re: Geotechnical Review – Grading and Landscaping Plans
Proposed Residential Development
475 Terry Fox Drive – Ottawa, Ontario

file: PG7418-MEMO.02 Revision 4

Drawing Title
GRADING PLAN
(NE CORNER)

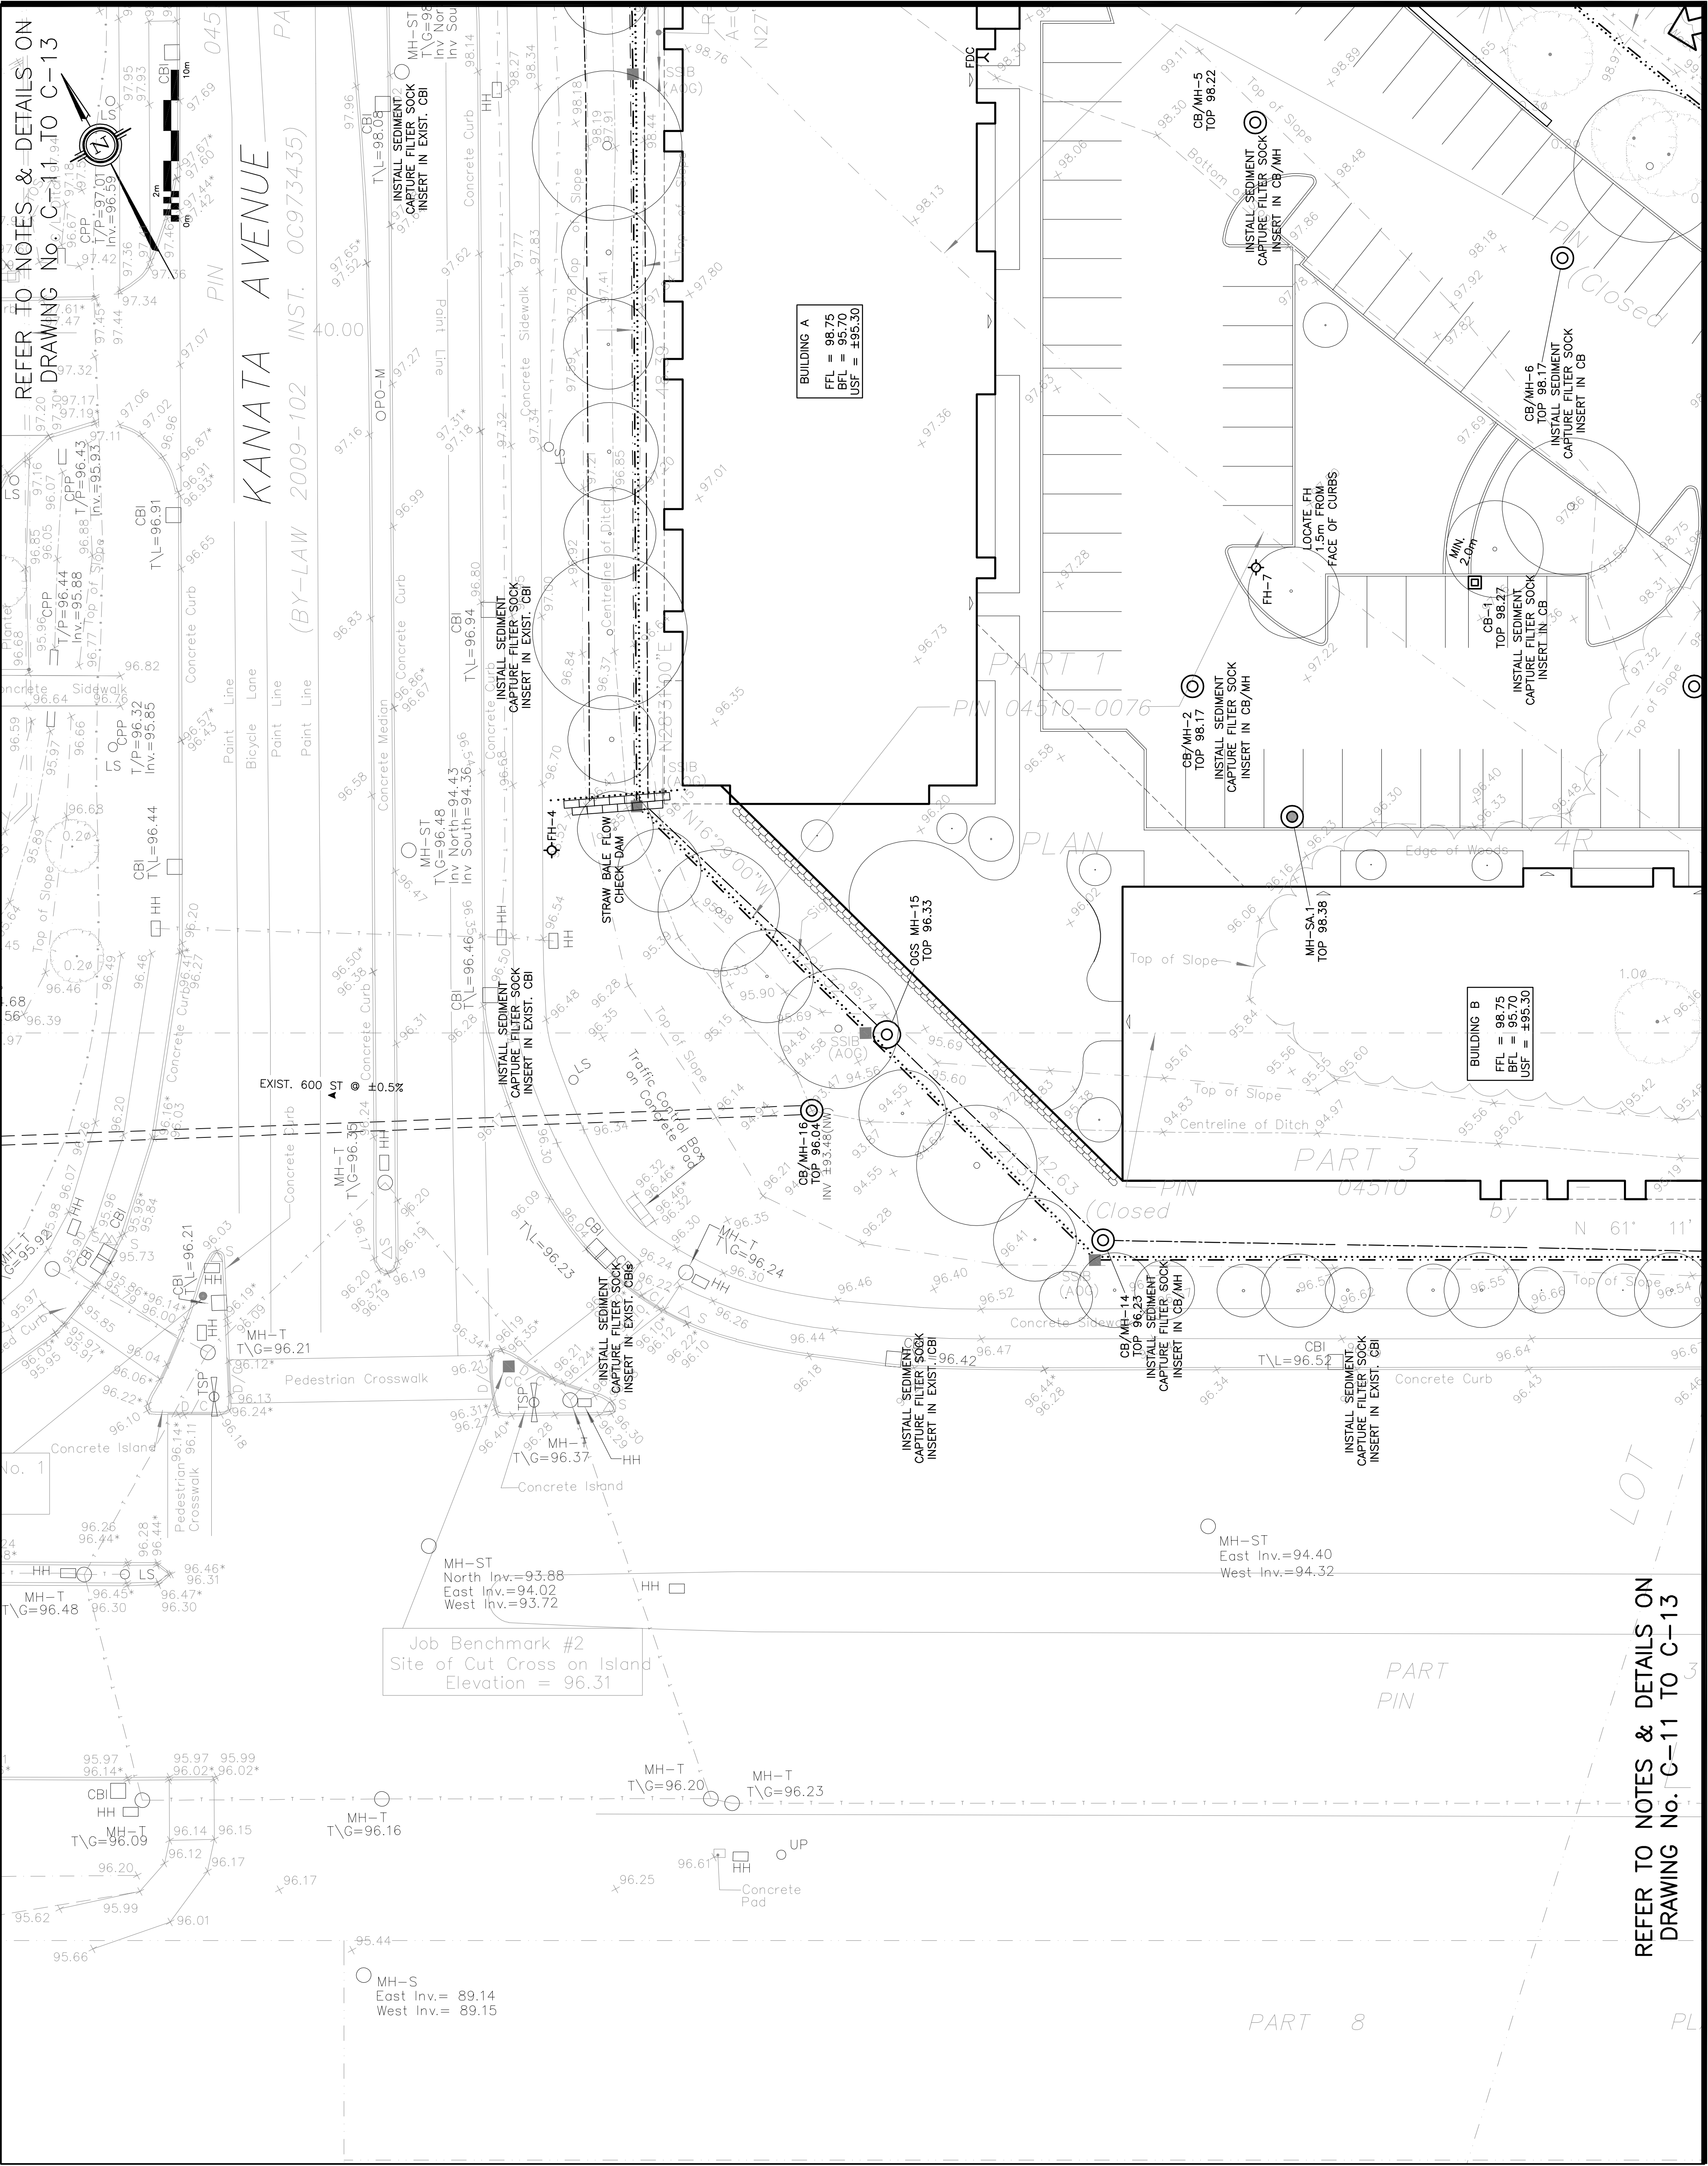
However, some grade raise exceedances were identified in areas surrounding the proposed Building B and Building C. For these areas, lightweight fill is recommended to be placed per the locations identified in Figure 1 below to accommodate the grade raise restriction exceedances and mitigate long-term settlements.

It should be noted that additional exceedances were identified along the eastern portion of Building B. However, based on our review, these exceedances are considered minor and tolerable from a geotechnical perspective such that lightweight fill is not considered required to accommodate those exceedances at this time.

Lightweight fill (LWF) should consist of EPS (expanded polystyrene) Type 19 and Type 12 geofoam blocks throughout hardscaped (paved or other areas with concrete surface features) and landscaped areas, respectively. The LWF is recommended to be placed a minimum of 500 mm above any perimeter drainage sleeves/pipes provided to the main building structures foundation and the associated open-graded stone layers. The lightweight fill should be placed upon a flat soil surface. Therefore, the soil should be compacted to be relatively smooth and flat prior to installation. Consideration may be given to placing a thin layer of sand or stone dust to attain a relatively smooth/flat surface for placement.

The entire lightweight fill layer footprint is recommended to be covered with a layer of polyethylene (taped at seams) extending between the building footprint and outer edge of the layer and extending below its surface by a minimum of 100 mm at all edges of the lightweight fill layer.

If the lightweight fill will be located in an area of landscaping, a minimum 600 mm of soil cover is recommended to be provided to the lightweight fill layer to promote grass and associated vegetation to establish overtop the lightweight fill. The placement of all lightweight fill should be reviewed at the time of placement by Paterson personnel. It is advised that a brief pre-construction meeting be held between Paterson and the construction team to confirm placement methodology prior to the installation.
